National Trust objection relating to SSD-31179510 Gregory Place Build-to-Rent

The National Trust of Australia (NSW) expresses its strong objections to the proposal for the construction of three separate, large scale buildings with 483 dwellings within the site located at 2A Gregory Place, Harris Park.

CONTEXTUAL RELATIONSHIP

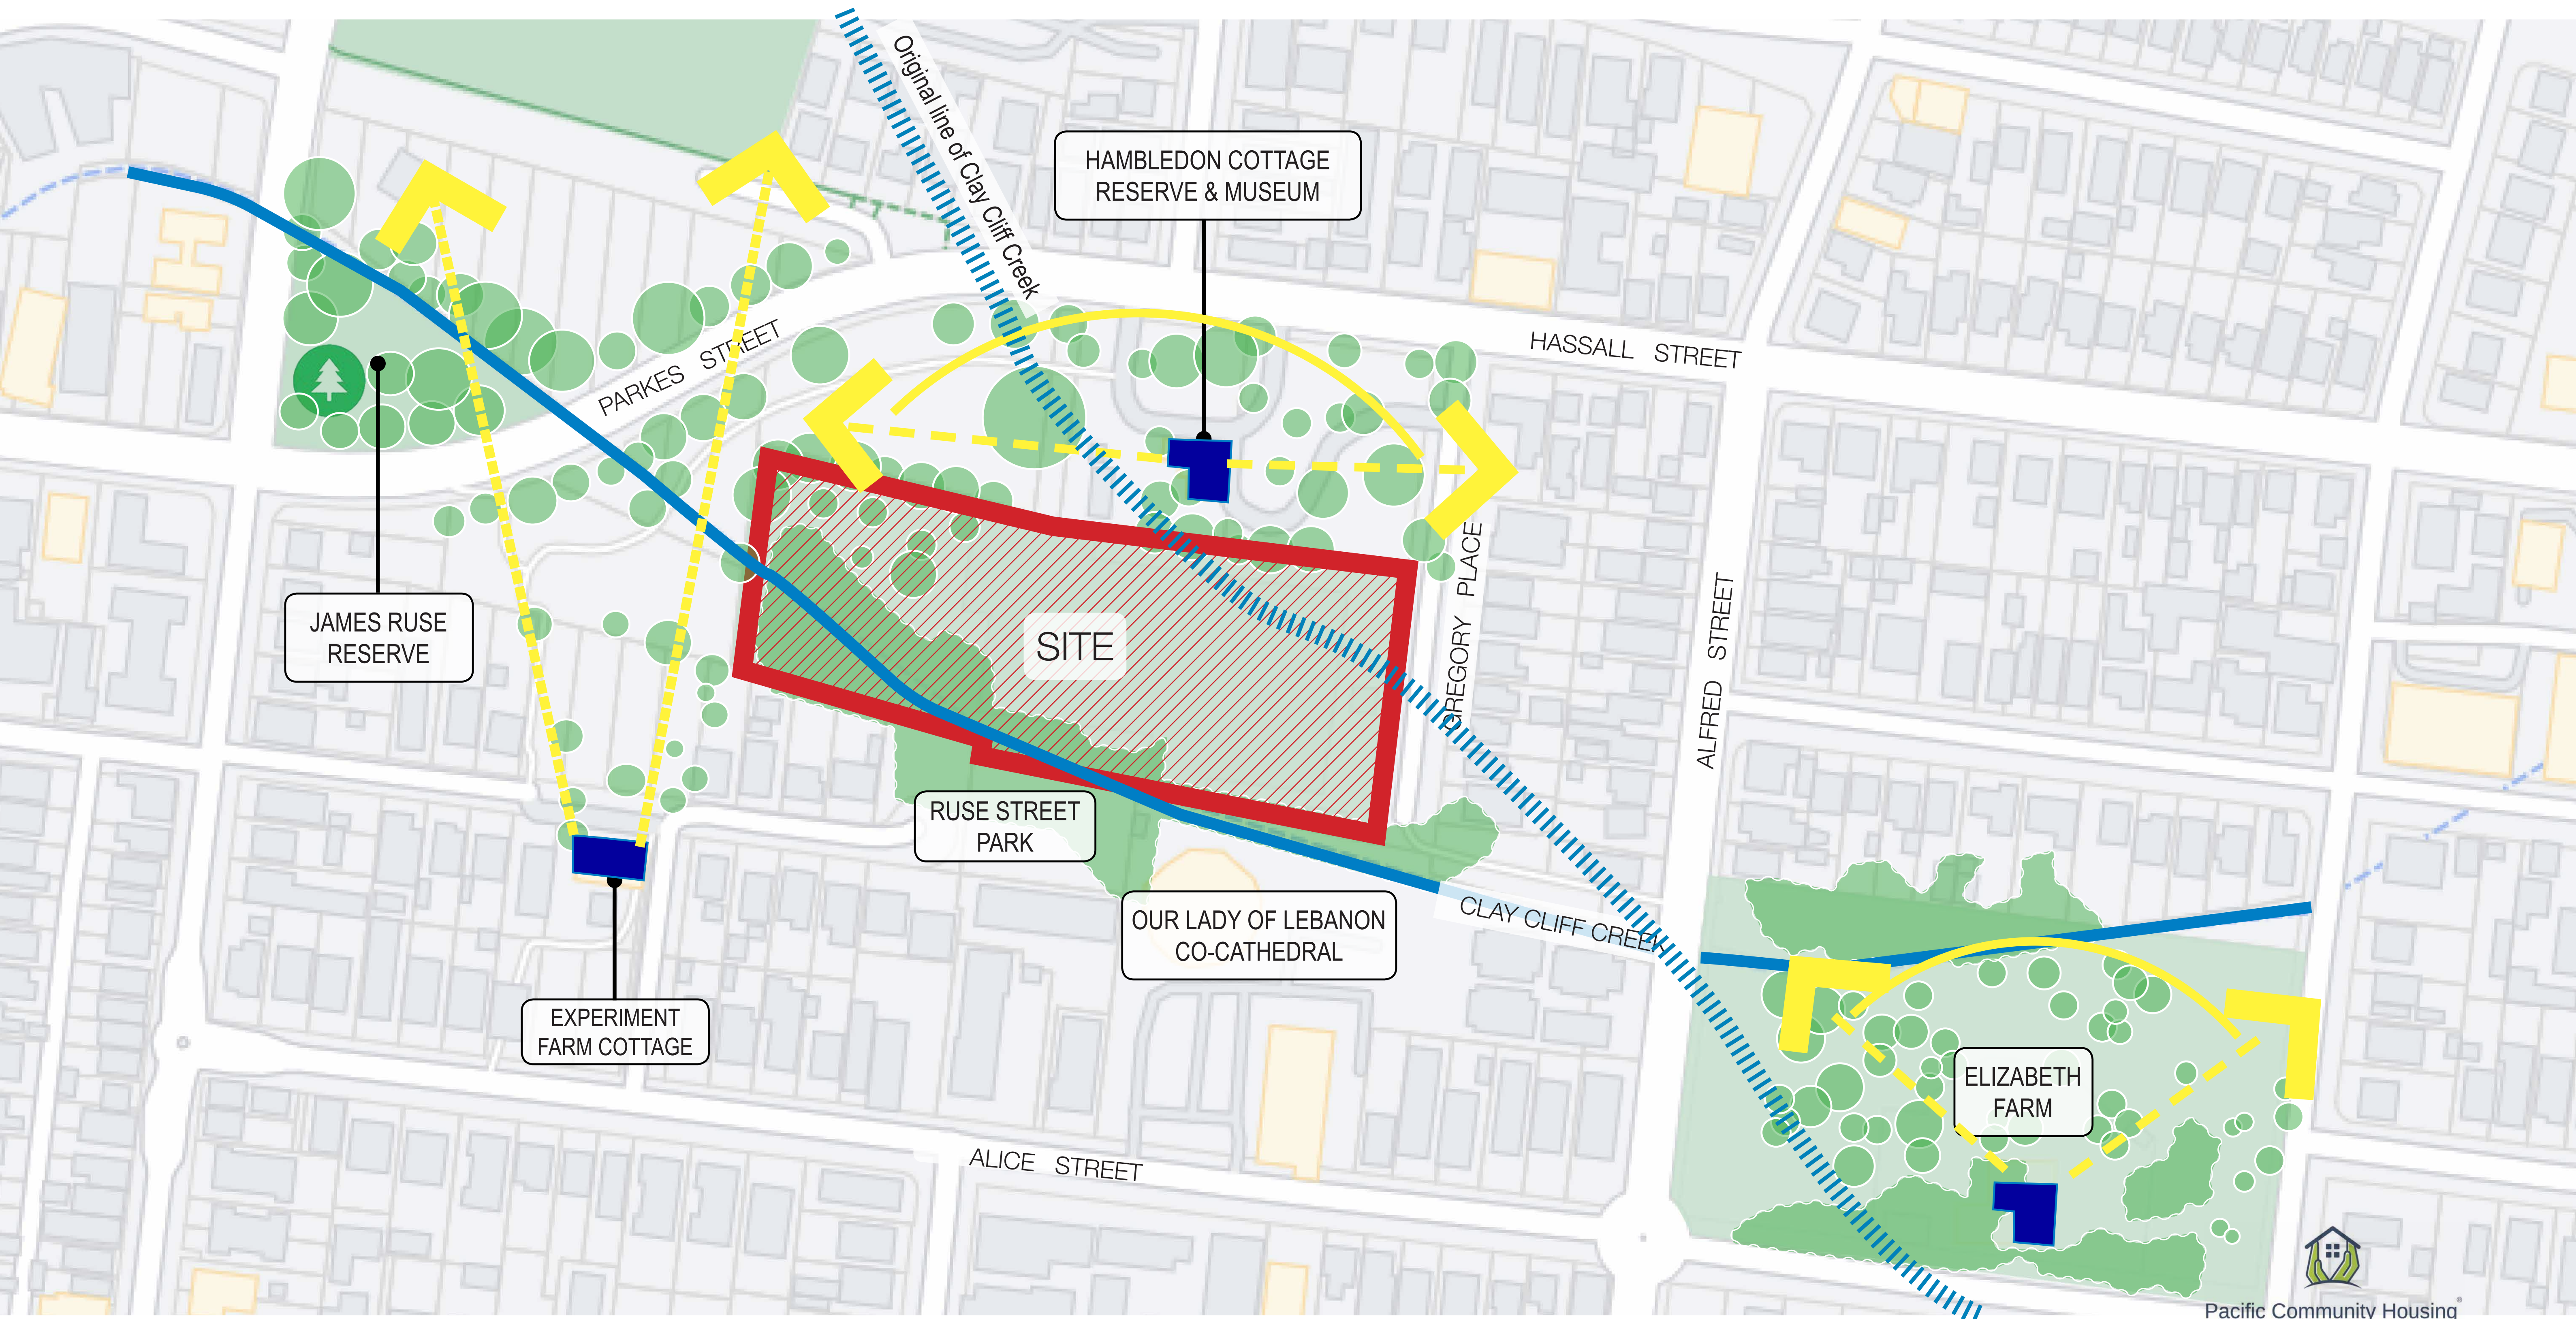
The National Trust are extremely concerned that the true impact of this proposal, particularly on Hambledon Cottage, has not been accurately represented in this proposal. The Visual Impact Assessment for this proposal of 483 apartments in one of the most visually sensitive locations in Australia contains only seven views, and most of them are irrelevant.

- Does not contain a single view from within the grounds of Hambledon Cottage;
- Does not include any views towards the development from the adjacent state-listed Experiment Farm or Elizabeth Farm properties;
- Does not include a single view from the Our Lady of Lebanon Co-Cathedral in Ruse Street;
- Does not include a single "public viewing point" from within any of the surrounding public reserves.

We totally dispute the claim in the Visual Impact Assessment (p.15) that the visual impact on Hambledon Cottage is Moderate/Low, and the argument that "Hambledon Cottage is subservient to the existing vegetation of the SHR." Hambledon Cottage, Elizabeth Farm and Experiment Farm are not "subservient" to vegetation. They are (individually and collectively) a rare grouping of colonial landscapes, including houses, trees and

The National Trust feel that a proper accurate and legitimate Visual Impact Assessment of this proposal must be produced and the public exhibition period recommenced with this information made available.
